From: Weekes, Cassandra L (DFW) <Cassandra.Weekes@dfw.wa.gov>
Sent: Wednesday, March 5, 2025 11:24 AM
To: Ellie Myers
Subject: RE: AU-25-00004 Wetzel - Notice of Application

Please review the following Boundary Line Adjustment: AU-25-00004 Wetzel. Any comments need to be received by **5 PM on March 5th, 2025**.

AU-25-00004 Wetzel Critical Areas

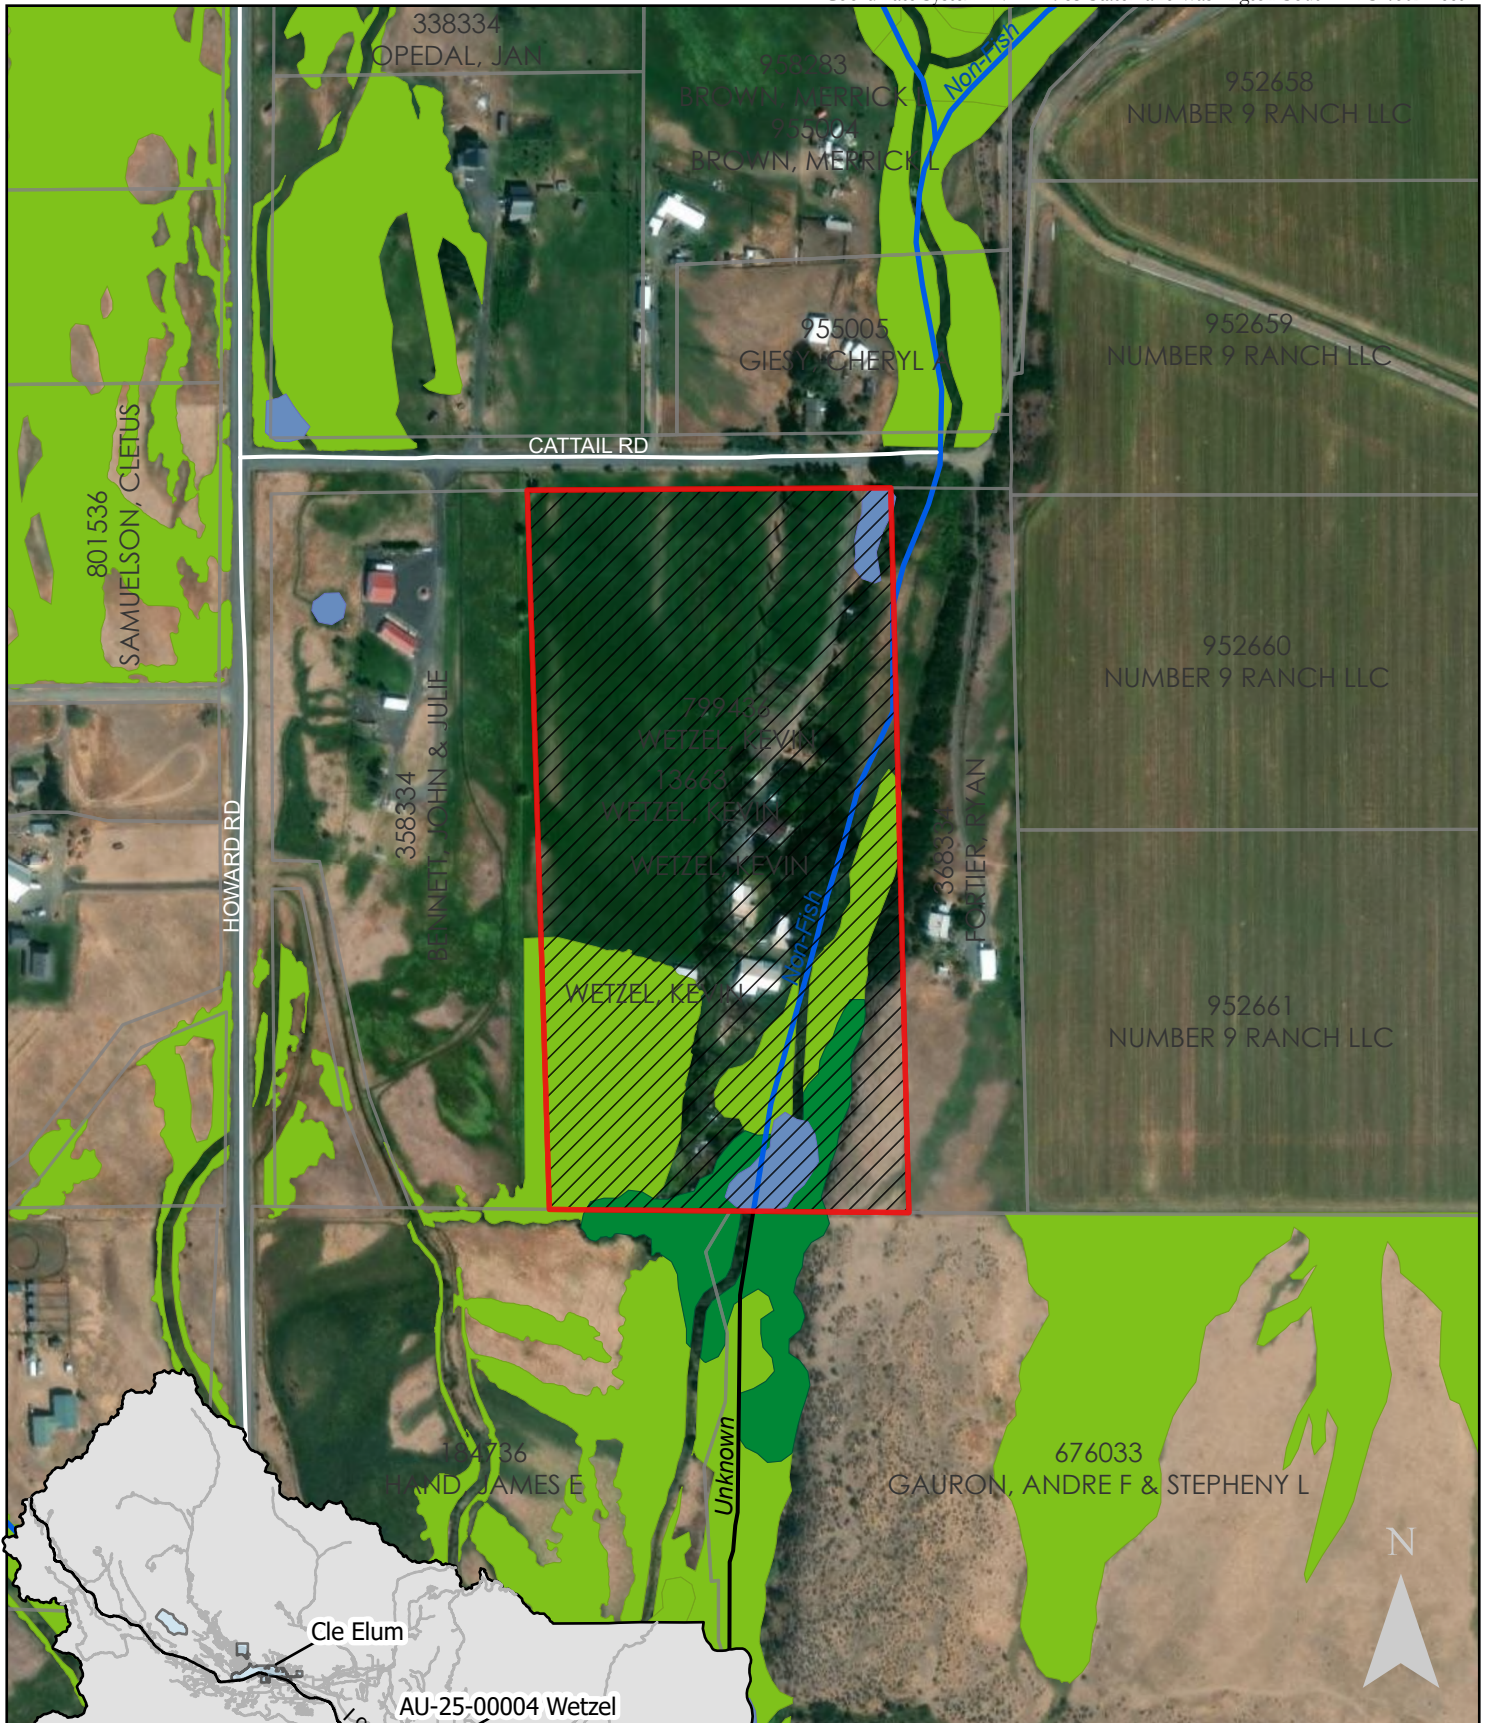
The stream located on the property is a tributary to Dry Creek, a fish-bearing tributary to the Yakima River. There are also several mapped wetlands along the stream corridor and southern end of the property. We recommend any proposed development near the stream and wetlands be evaluated for consistency with Kittitas County's Critical Areas Ordinance. Proposed work in or near the stream will require a Hydraulic Project Approval from WDFW.

We appreciate that as currently shown on the site plan, the new development will be outside of the stream and wetland buffers.
